Rezoning Transportation Analysis

Petition Number: #2022-105

Revision Log:

Date	Description
11-28-22	First Review (PM)
12-22-22	Second Review (DR)
2-22-23	Third Review (JP)
12-19-23	Fourth Review (IW)
04-09-24	Fifth Review (IW)

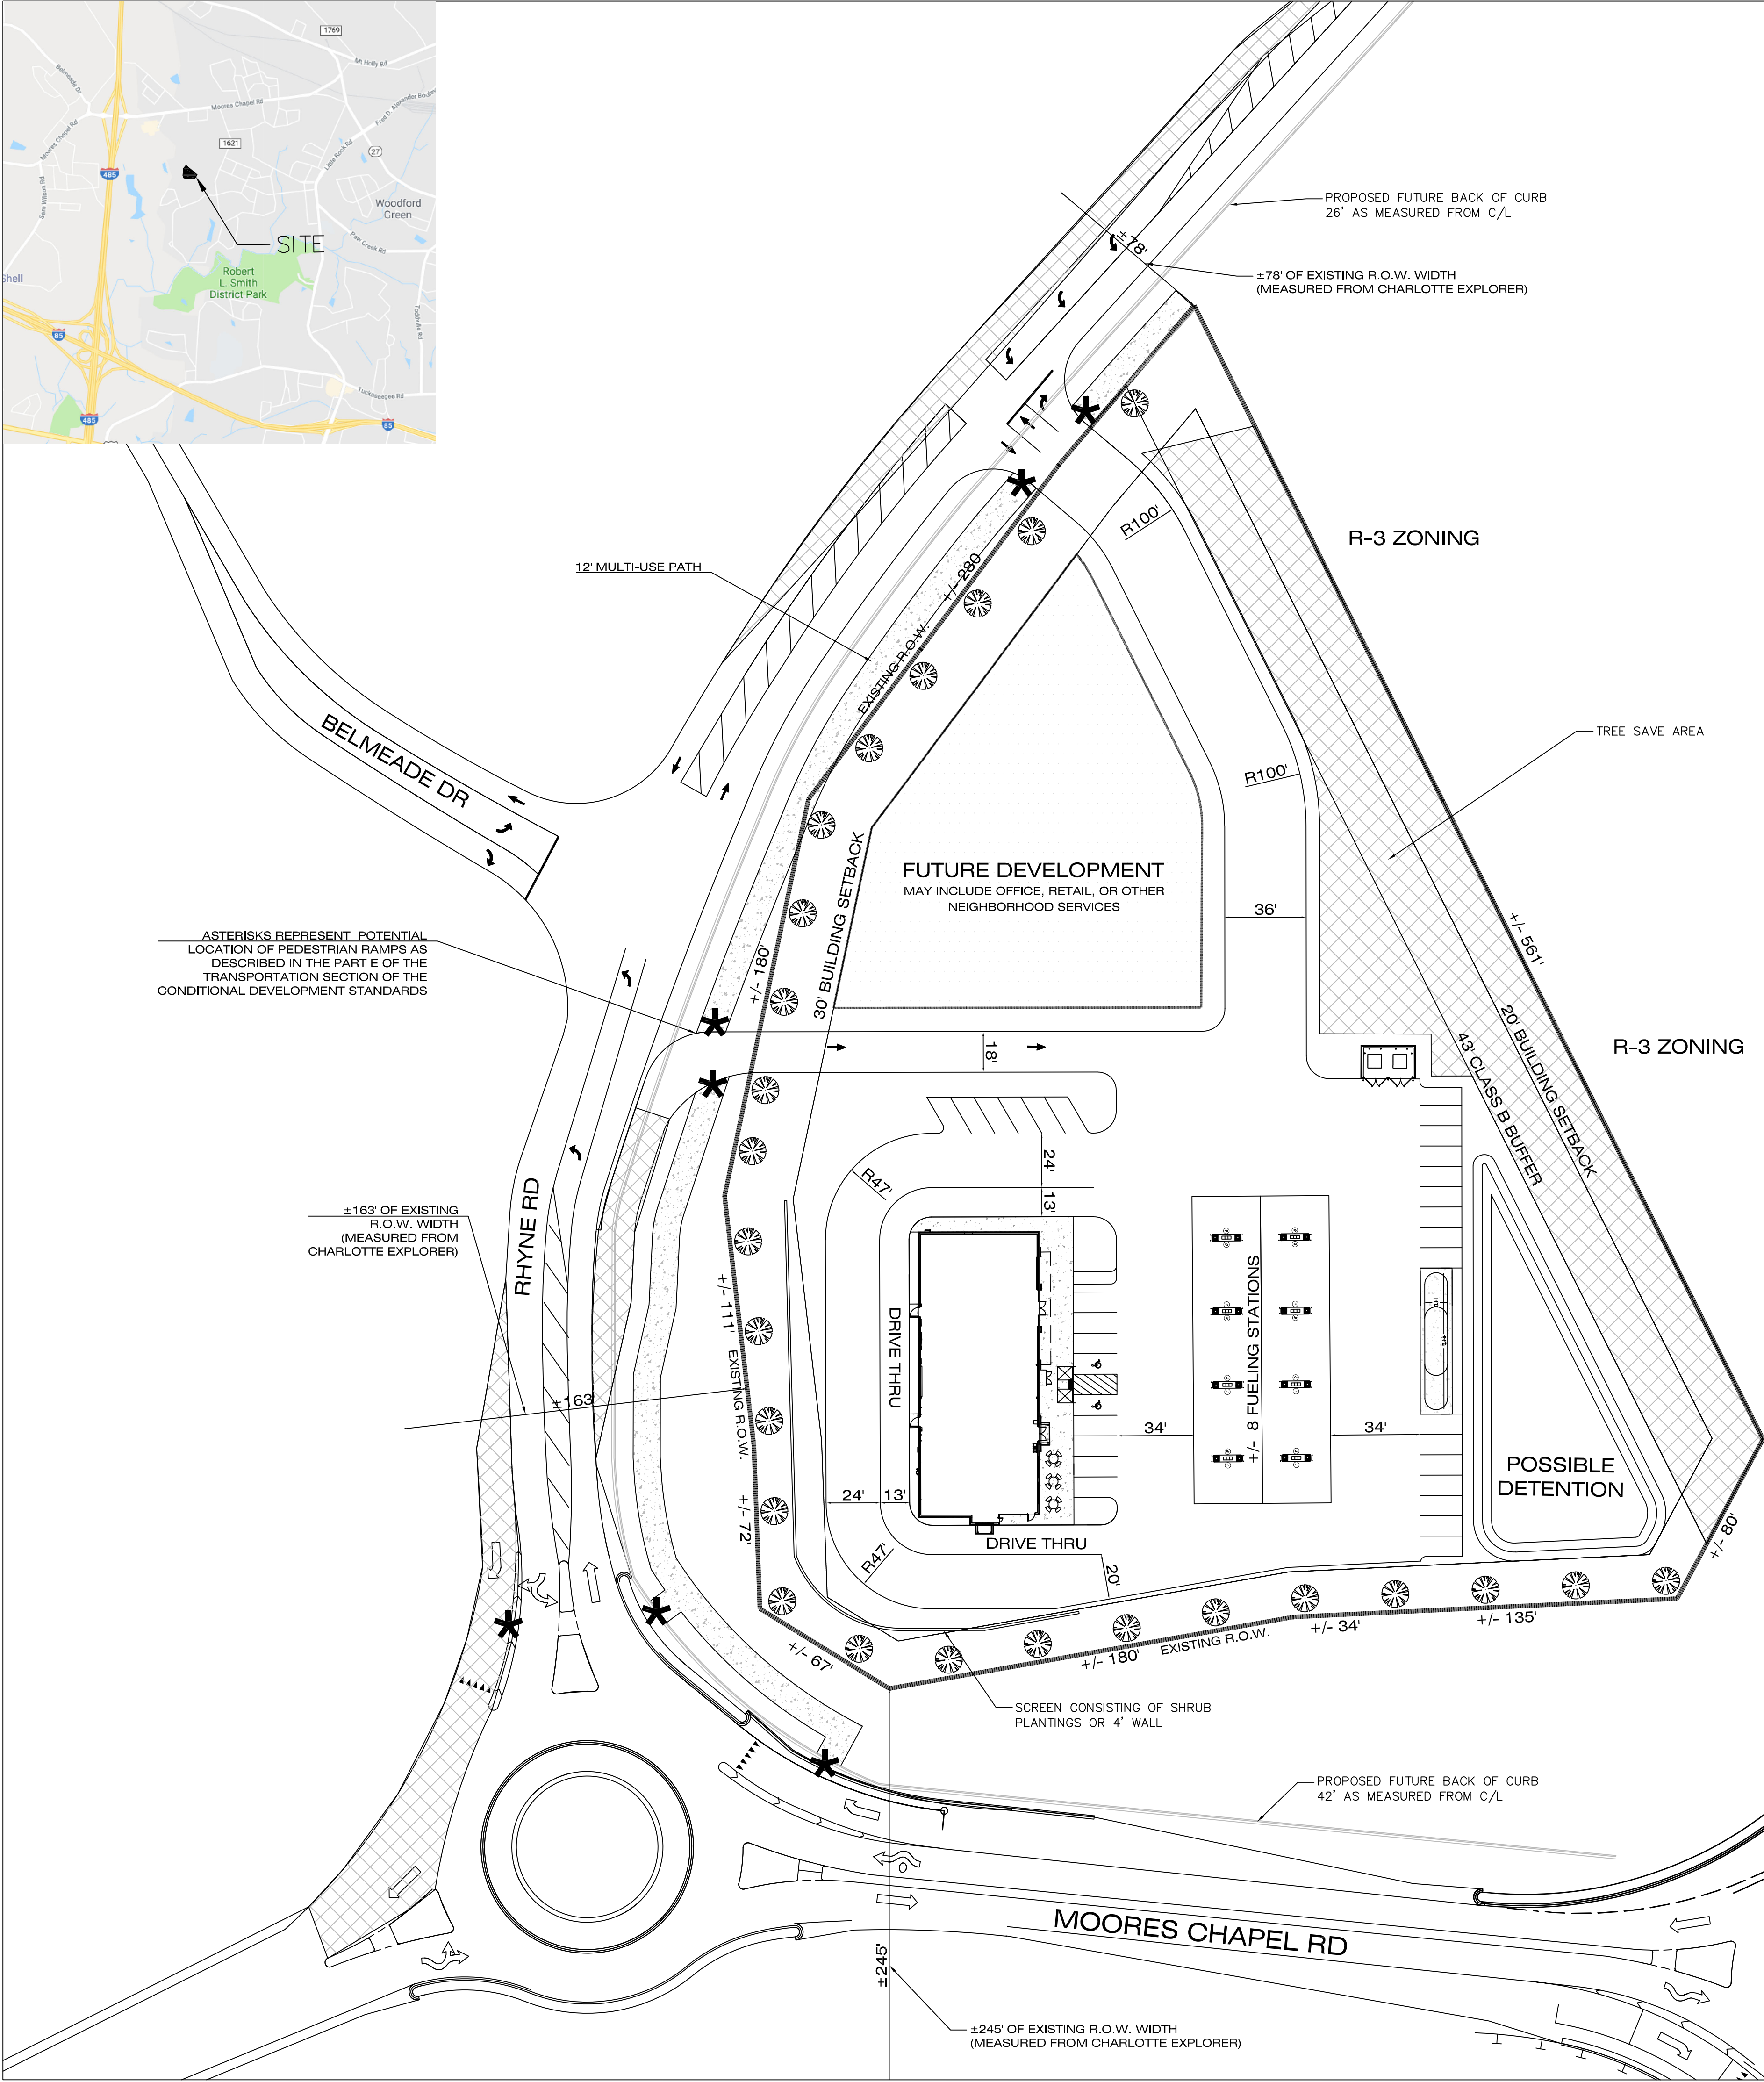
~~2. **Outstanding Comment** Revise site plan conditional note in the transportation section letter e. for Southbound I-485 Off Ramp to say, "Extend existing southbound right turn lane to provide 400' of storage and appropriate taper."~~

REWORD:

Extend SBR to provide 400' of storage and appropriate taper.

Existing SBR is 200'.

Clarifying Comment from 12/22/2022: Reword improvement at Southbound I-485 Off Ramp to what is shown in the picture above.

New Comment from 04/09/2024: Remove improvement below. "Convert the southbound right turn lane to a free flow right" is mentioned twice. Then add the following to the first sentence for the Moores Chapel at I-485 SB Off-Ramp intersection "Convert the southbound right turn lane to a free-flow right with channelization island."

3. **New Comment from 04/09/2024:** Remove improvement below. This has already been constructed. Only improvement at Rhyne Road and Belmeade Road intersection should be what is circled below.

4. **Outstanding Comment** Revise site plan and conditional note(s) to provide 12-foot multi-use path and 8-foot planting strip along all public road frontages (Moores Chapel Road, Rhyne Road, Belmeade
